ALTUS PAGE KIRKLAND

CAMPBELL'S STORES

DA ACCESS REVIEW

26 October 2015

Drawing Title  
**HICKSON ROAD LEVEL 01 PLAN**  
Drawing Number  
**12006**  
Drawing Status  
**EA**  
Drawing Number  
**EA-A-1002**  
Revision  
**B**

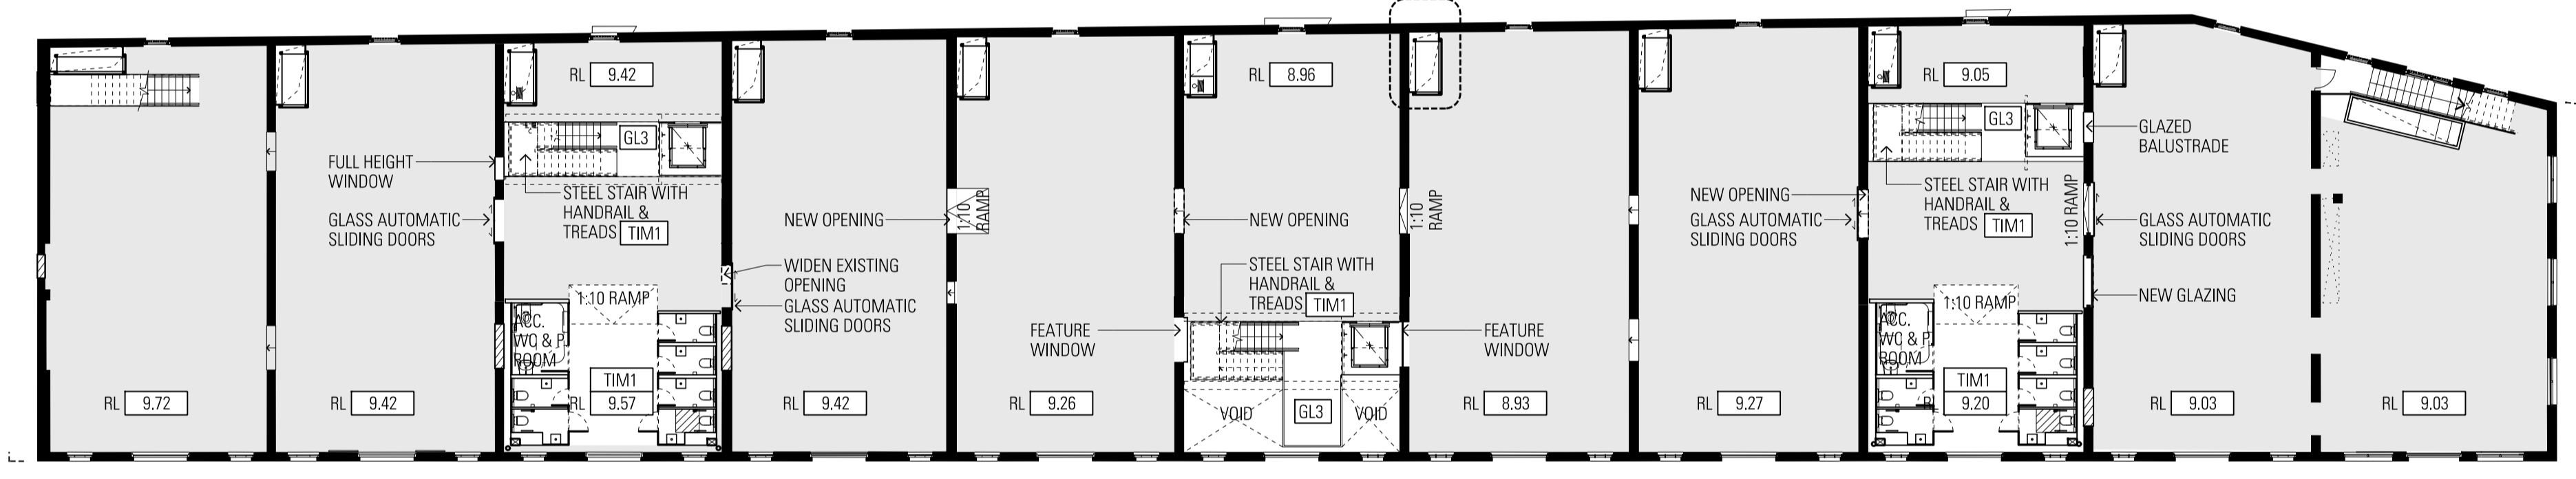
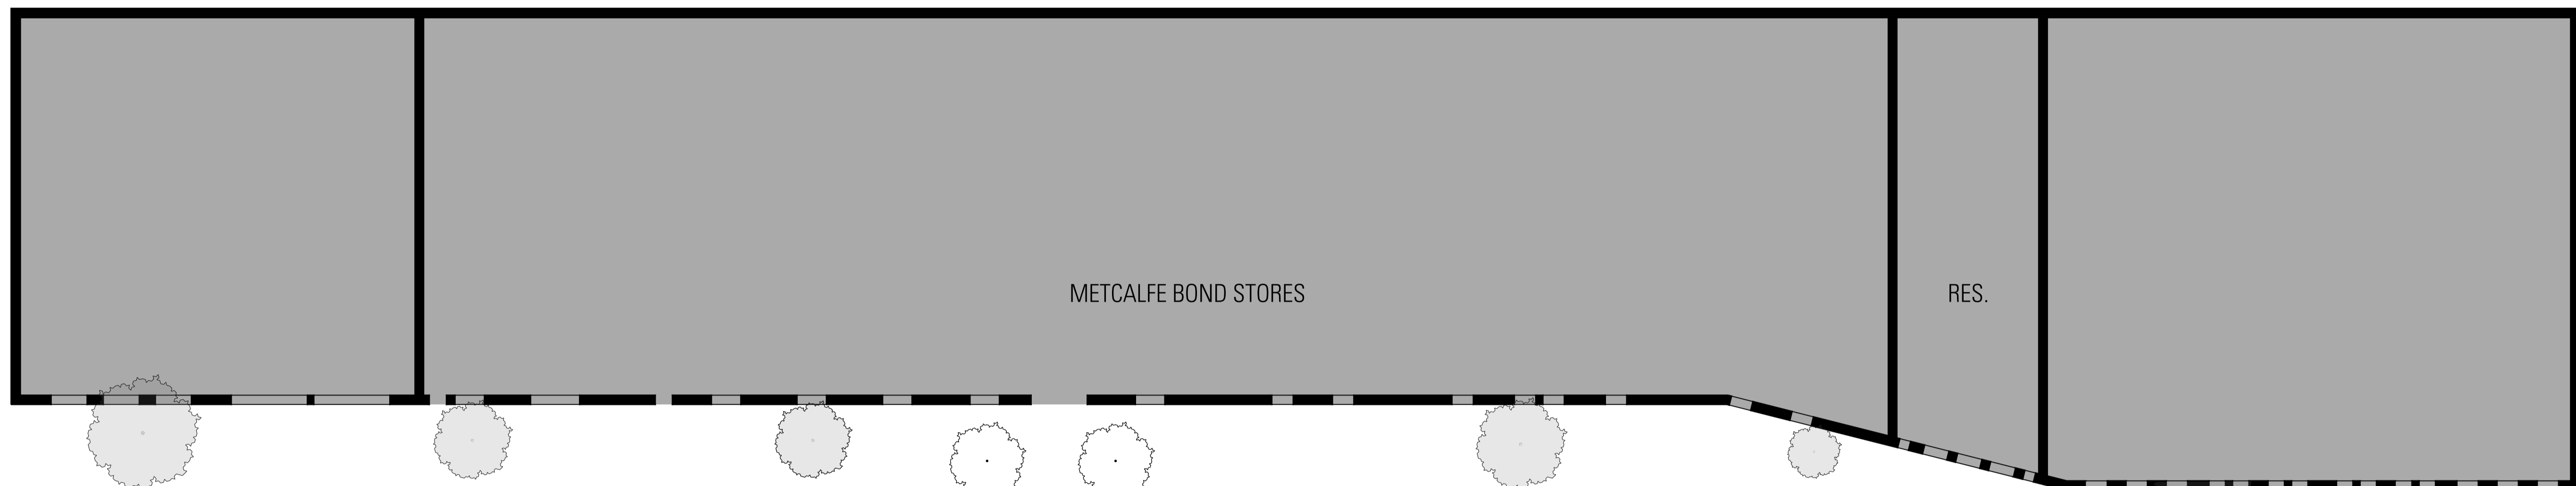
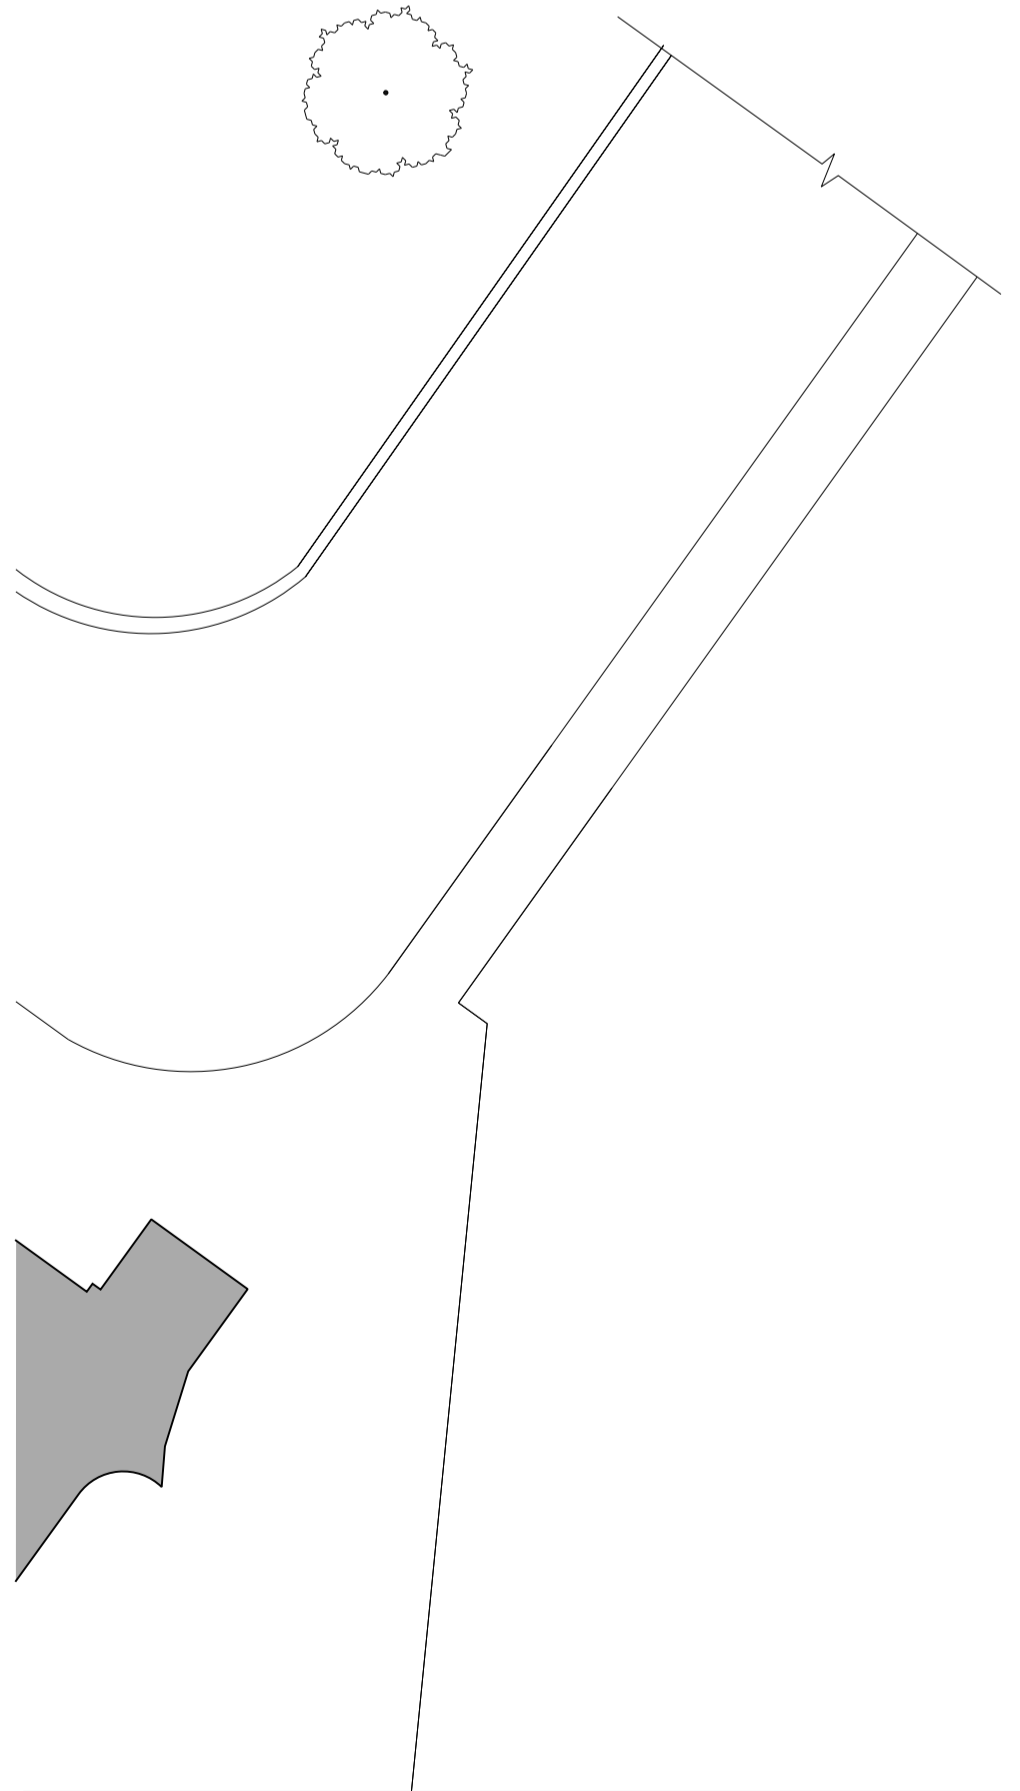
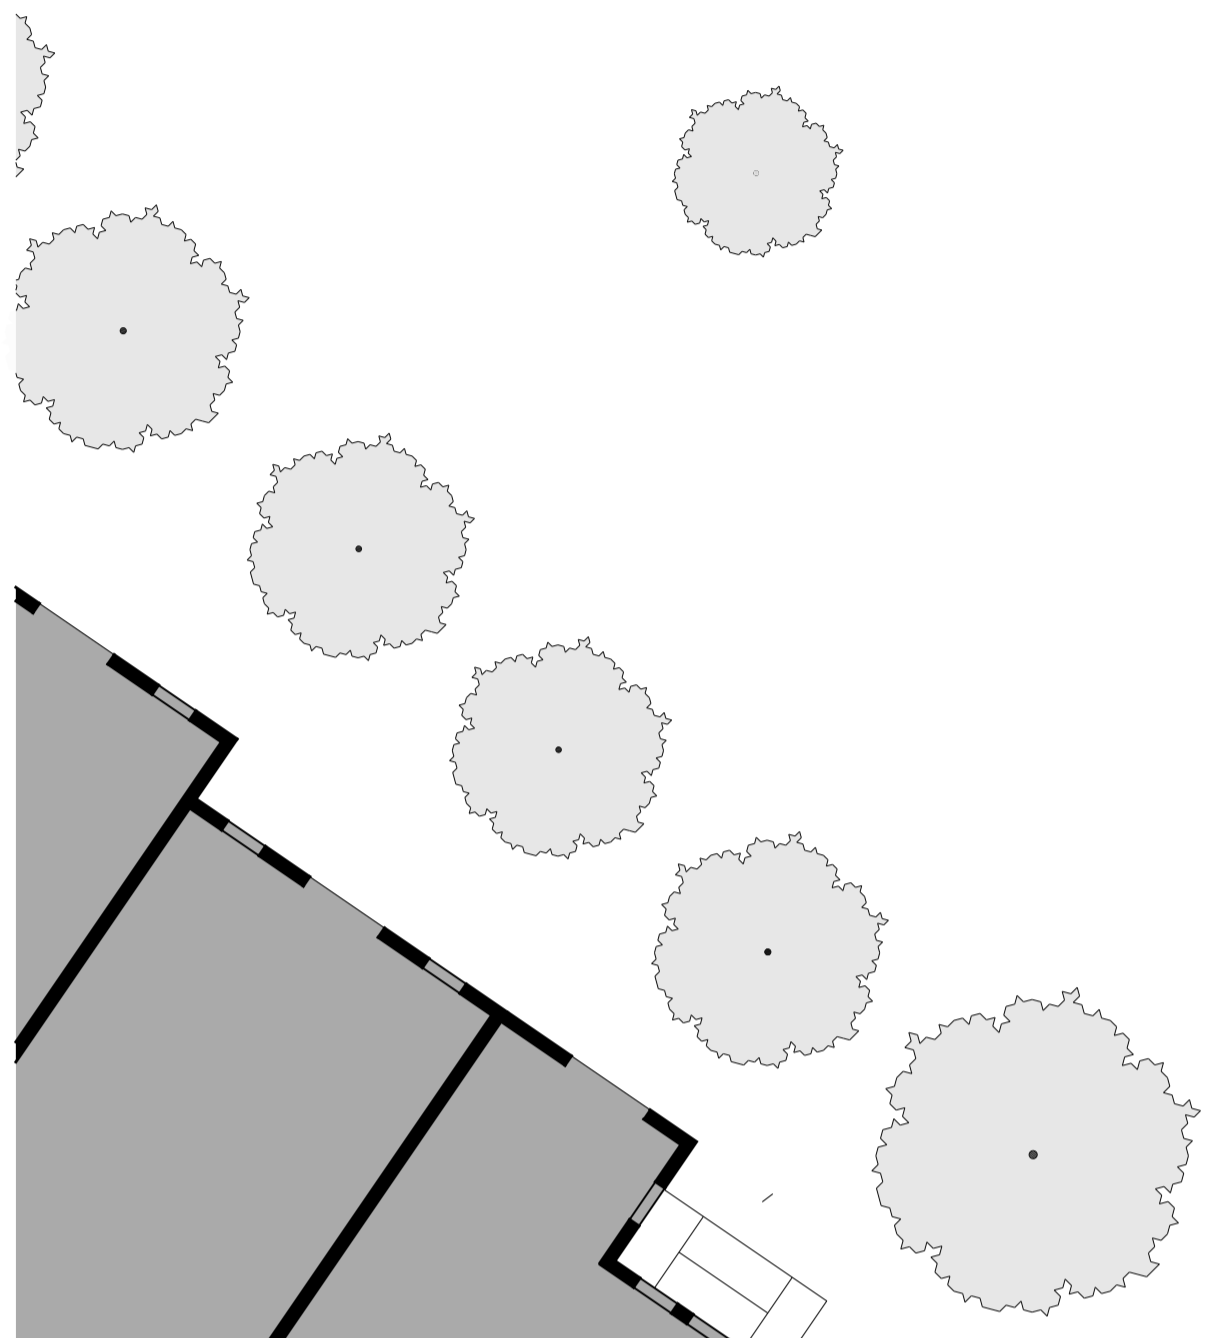
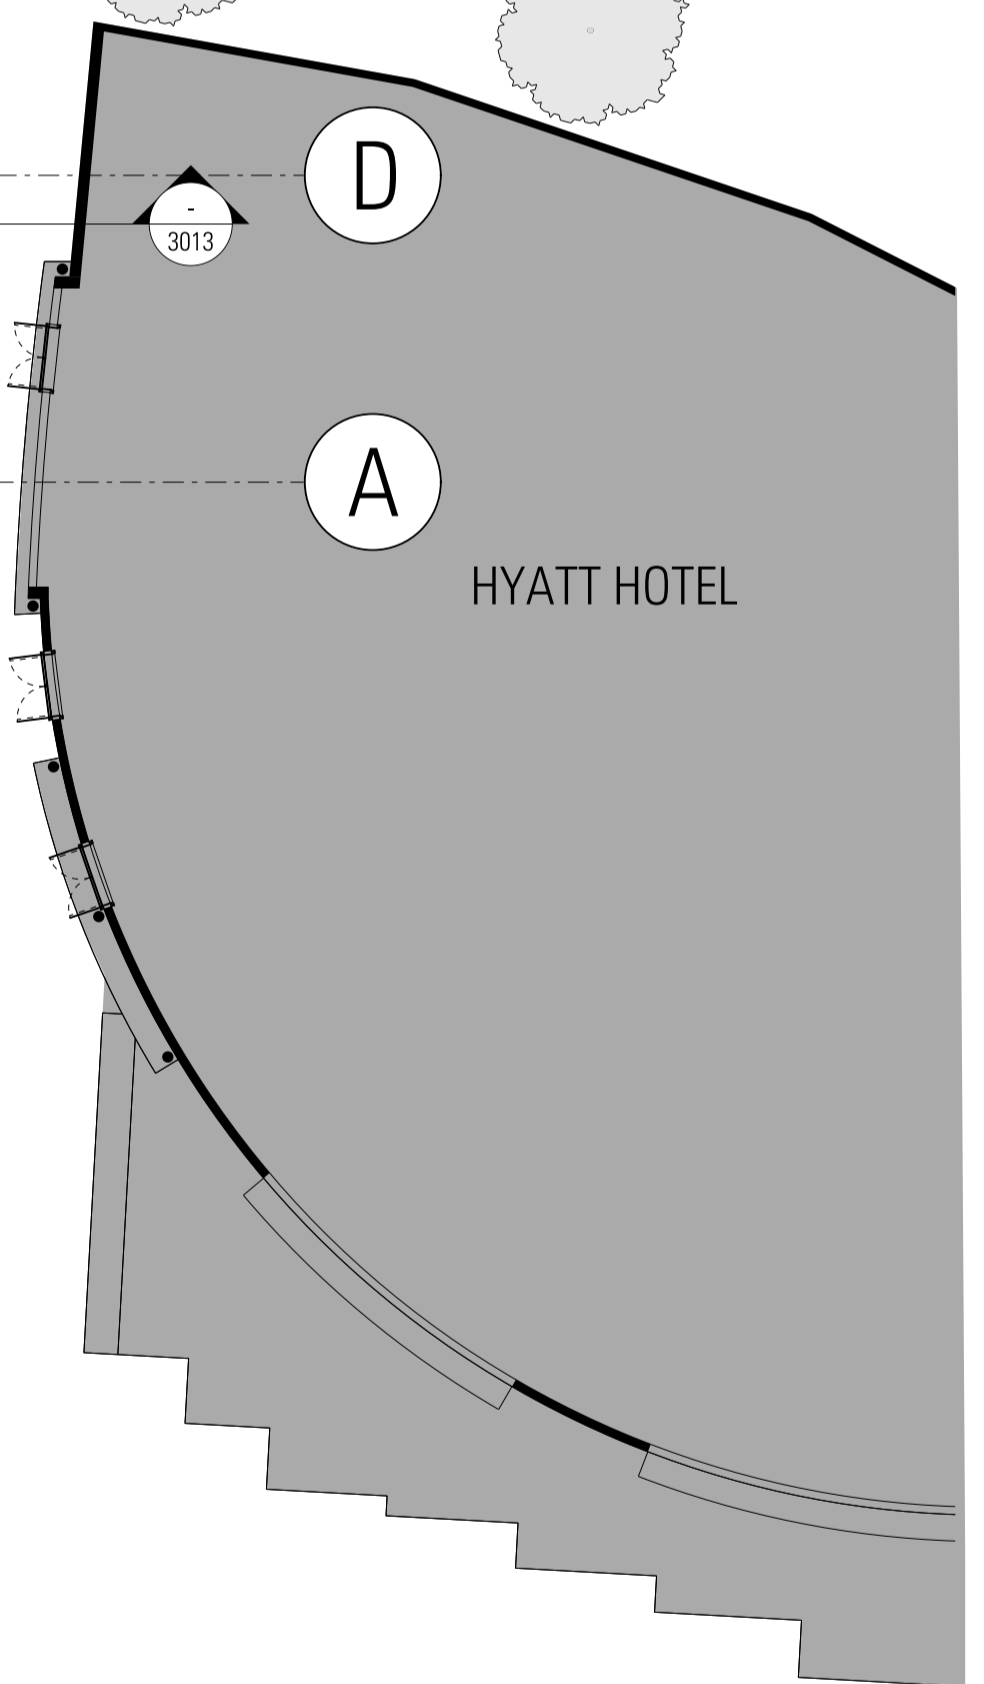
A new raised pedestrian crossing is indicated on western side of building opposite bay 5/6 with new kerbs proposed to provide improved pedestrian traffic and safety. Review will be required of the proposed surface to ensure accessibility for people with disabilities, compliant with AS1428.1.

- (i) Provide new stairways with stair configuration and handrails on both sides of the stair, compliant with AS1428.1:2009. Note: stairs to be recessed by 900mm at base on site boundary so that handrail extensions and TGSIs are not located on public footpath/transverse paths of travel.
- (ii) Ensure new pedestrian crossing and connecting footpath linkages to accessible building entrances on Hickson Road are accessible to people with disabilities, compliant with AS1428.1. Note: cobble paving surfaces are not generally compliant with AS1428.1 due to uneven surface profile variations.

The main entrance to Bay 6 is an existing opening that has been widened with new glazed automatic sliding doors with 850mm min. clear width, in accordance with AS1428.1:2009 and DDA Premises Standards (Affected Part). From the main entry there is continuous access to the passenger lift that provides continuous access to level 01 and 02. The circulation area at the main entry doorway and lift can accommodate wheelchair turning and passing spaces, compliant with AS1428.1:2009.

- (i) Ensure the threshold ramp or step ramp with landings at each required accessible tenancy main entry door is compliant with AS1428.1:2009. Note: exposed sides of ramps are to have a 45 degree splay for safety (transverse traffic) or be protected by a suitable side barrier.

The main entrance to Bays 3 and 9 is an existing opening that has been widened with new glazed automatic sliding doors with 850mm min. clear width, in accordance with AS1428.1:2009 and DDA Premises Standards (Affected Part). From the main entry there is direct access to the passenger lift that provides continuous access to level 02 (Note: there is restricted access only to level 01 to staff/service corridor). The circulation area at the main entry doorway and lift can accommodate wheelchair turning and passing spaces, compliant with AS1428.1:2009.

- (i) Ensure the threshold ramp or step ramp with landings at each required accessible tenancy main entry door is compliant with AS1428.1:2009. Note: exposed sides of ramps are to have a 45 degree splay for safety (transverse traffic) or be protected by a suitable side barrier.

There is a new alternate entry proposed at level 01 to tenancy (bay 1) that leads to/from the tenancy to the new associated outdoor service area on the stair terrace. The new opening has 850mm min. clear width, and circulation area at new entry doorway, in compliance with AS1428.1:2009.

- (i) Ensure the new alternate entry door level 01 to tenancy (bay 1), is compliant with AS1428.1:2009
- (ii) As the new alternate entry at level 01 to tenancy (bay 1) outdoor area is not accessible from Hickson Road footpath, provide an alternate accessible internal route (via bay 1, 2) from Bay 3 Hickson Road main entrance/s, level 01.
